To Protect and Promote the Health and the Environment of the People of Kittitas County

February 3, 2025

RE: SP-25-00001

KCPHD has reviewed the application and has provided the following comments regarding SP-25-00001:

GRAF SHORT PLAT

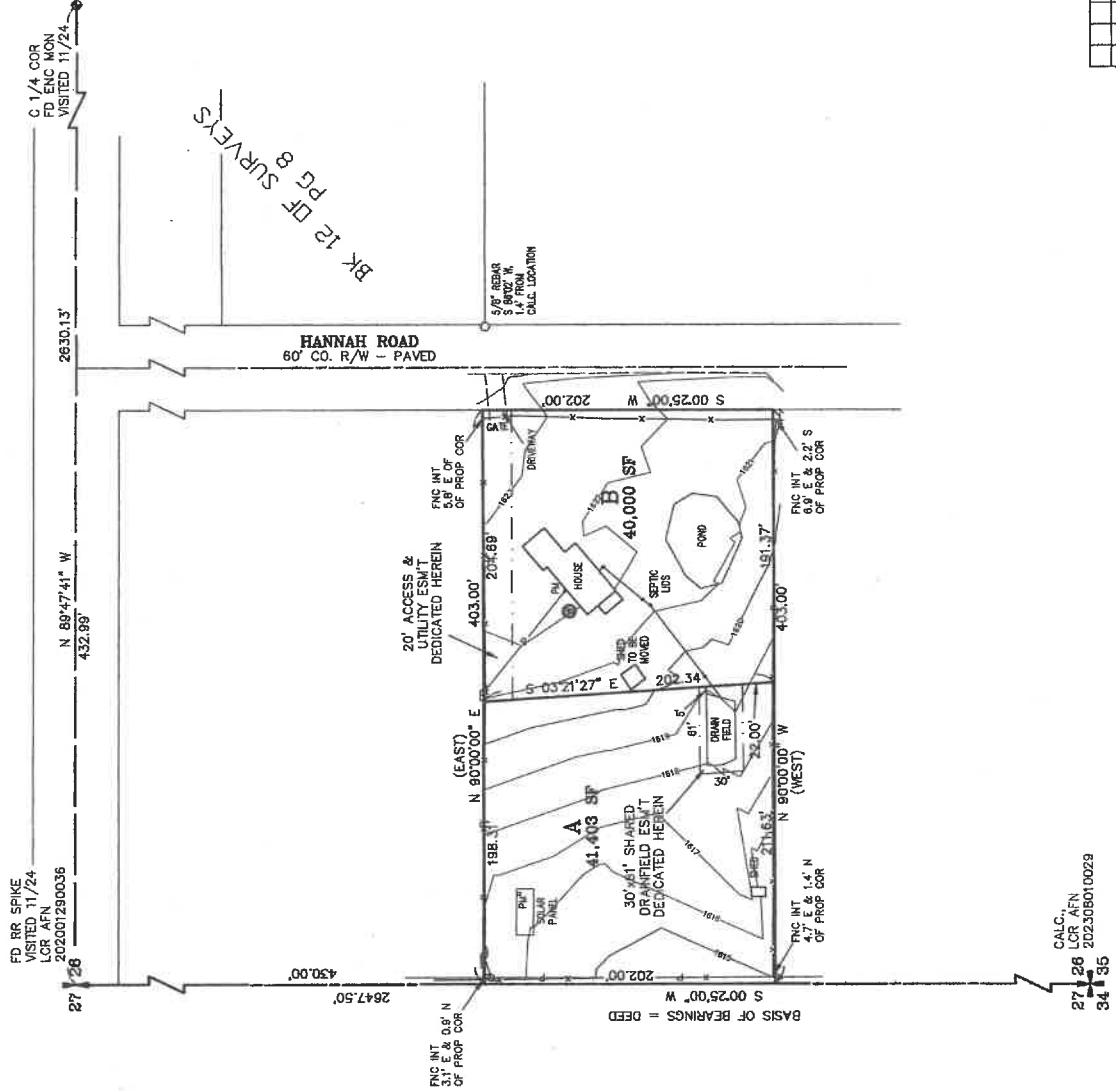
The proposed plat split of 841133, a 1.87-acre plat, into two plats, one measuring 41,403 square feet and the other 40,000 square feet, with existing septic and well systems, cannot be approved at this time due to current regulatory requirements. The primary issue is that the proposed plats do not meet the minimum land area requirements for developments with individual wells, as outlined in Washington Administrative Code (WAC) 246-272A-0320.

Under the regulations, effective until April 1, 2025, a minimum of one acre (43,560 square feet) per unit of sewage volume is required for soil types 1-4 when using an individual well. For soil types 5 and 6, a minimum of two acres (87,120 square feet) is required. On June 24, 2024, the soil type for the parcel was classified as type 4, which requires a minimum of one acre per lot. As such, both proposed lots fall short of meeting the minimum land area requirement.

Additionally, the WAC requires individual water supplies having at least one acre per unit volume of sewage. Also, each lot must provide a 100-foot radius water supply protection zone, which must be accounted for in addition to the minimum land area requirements. The 100-foot radius applied to public water systems as well.
